# OAKLANDS FARM SOLAR PARK

Response by the Applicant on Glint and Glare Matters

Document Ref: EN010122/D5/13.12

### Response by Pager Power to Action Point 6(c) - Additional Explanation for REP4-011 Responses

Figure 4 Assessed road receptors

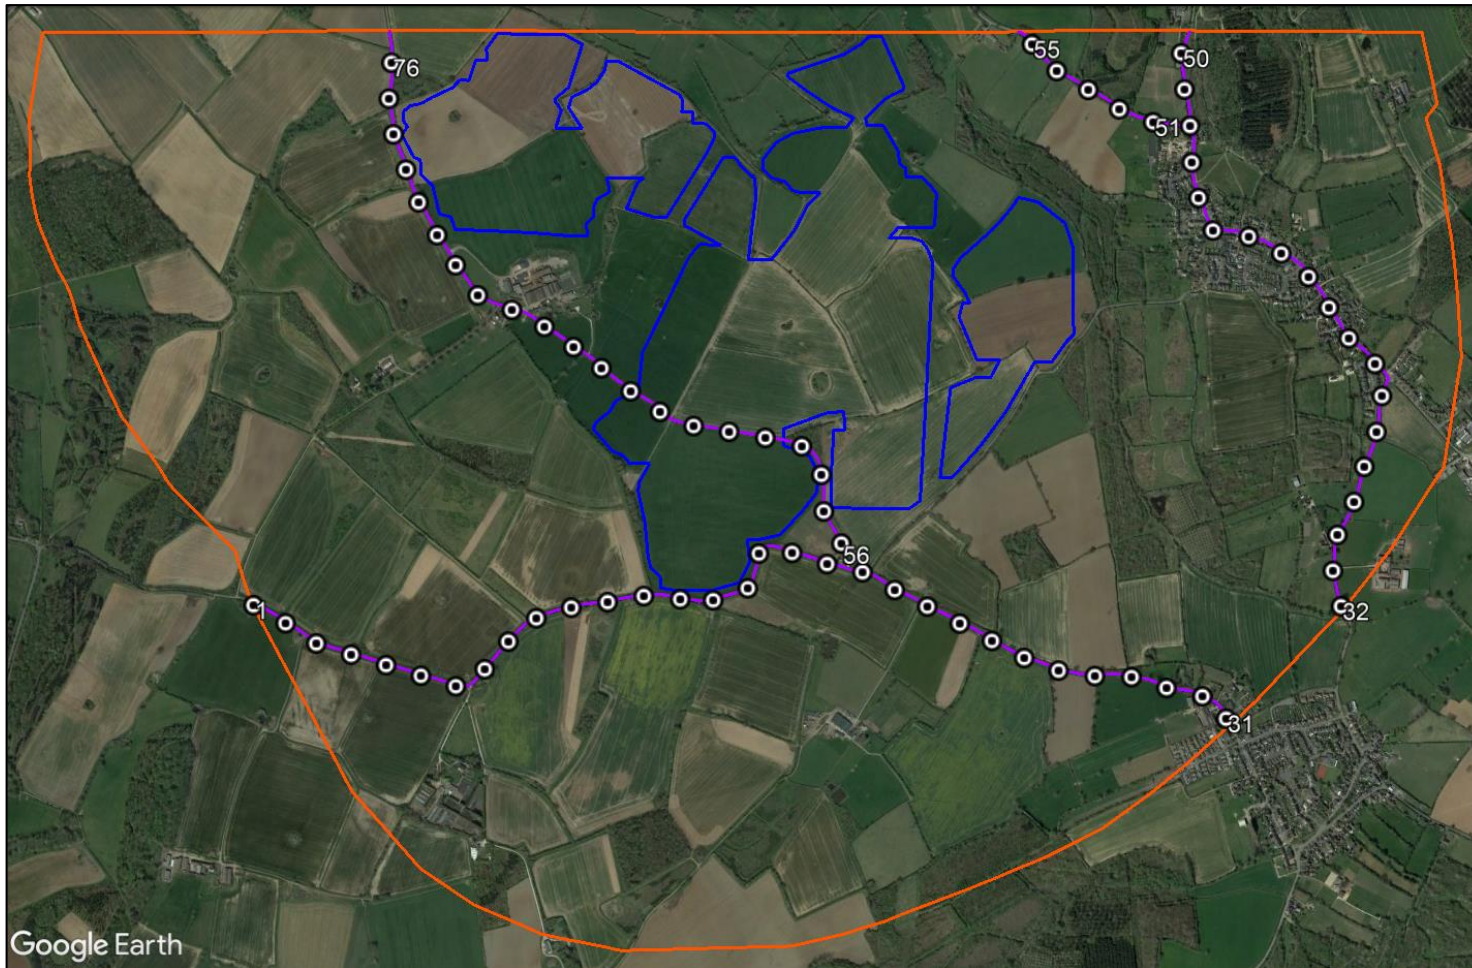
Pager Power considers elevated road users along motorways and dual carriageways due to the density of elevated road users along these road types. On behalf of SDDC, Mabbett undertook an independent review of Oaklands Solar Photovoltaic Glint and Glare Study [REP4-034] which concluded that:

*"Pager Power have assessed all road receptors at a height of 1.5m. It is stated in the report that "this height is used for modelling purposes. Small changes to this height are not significant, and views for elevated drivers are also considered in the results discussion, where appropriate". Later in Section 6.4 it is stated that "Whether visibility is likely for elevated drivers (applicable to dual carriageways and motorways only) – there is typically a higher density of elevated drivers (such as HGVs) along dual carriageways and motorways compared to other types of road". Mabbett agree that this approach is reasonable."*

Based on Pager Power's methodology, impacts on horse riders are not assessed as solar reflections from solar panels are of very similar intensity to those of common outdoor reflective surfaces, which are commonly encountered by horses and riders in a rural environment. The studies that show this are presented in Appendix B of ES Appendix 14.1.

Figure 5 Assessed dwelling receptor overview

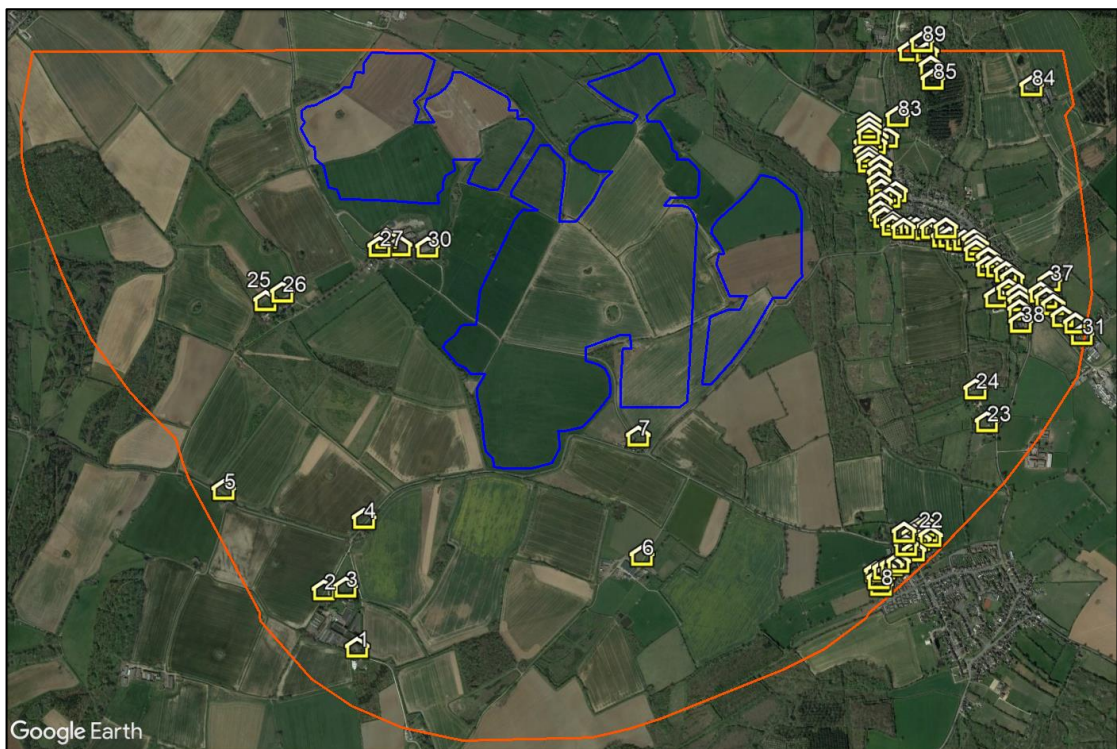
*“Residential dwellings were modelled at an additional height of 1.8m above ground level to simulate the typical viewing height of an observer from ground floor. It is stated in the report that “consideration of views from upper floors are also considered in the results discussion, where appropriate”. Later in Section 6.4 it is stated that “the ground floor is typically considered the main living space and therefore has a greater significance with respect to residential amenity”. Mabbett agree that this approach is reasonable.”*

The modelling output for the ground floor of each dwelling is then used to determine the reflecting panels towards the first floor, and a judgement of visibility is made using a combination of desk-based imagery, site photography, and a site visit.
